**2<sup>nd</sup> ROUND OF FINAL COMMENTS ON THE  
MODIFICATION OF MAJOR PROJECT  
06\_0063**

**THE PROPOSED REDEVELOPMENT OF CRONULLA MARINA**

**60 Waratah Street, Cronulla**

**Cronulla Marina – Advice to the Director General**

Figure 6 – Proposed Slipway Layout

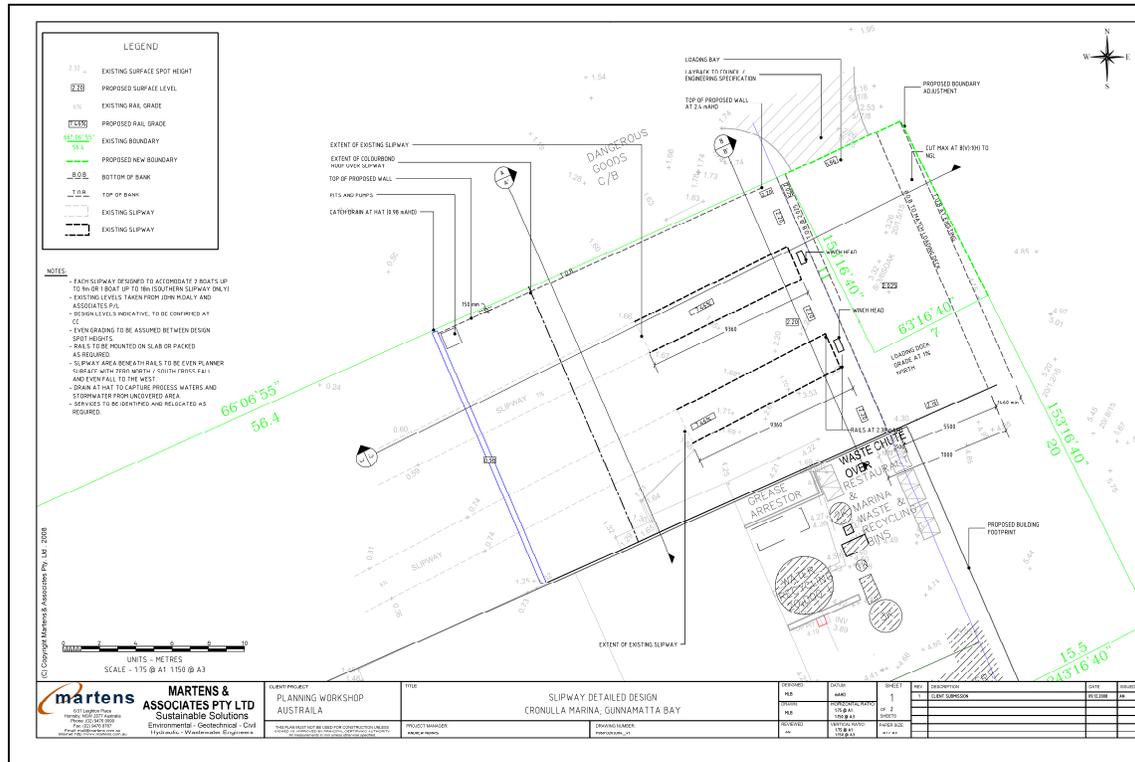
- The EPA is adamant that they will not support any pumping of any water into the Bay. All water collected on the slipway concrete surface including rainwater must go to a Sydney Water sewer system or be treated on site for re-use.
- We believe that two (2) full width grated catch drains should be installed at the lower end of the slipway. We have taken on board the Proponents comments of May 15, 2009 and recommend a full width grated catch drain at R.L.1.100 (A.H.D.) and R.L.1.225 (A.H.D.).
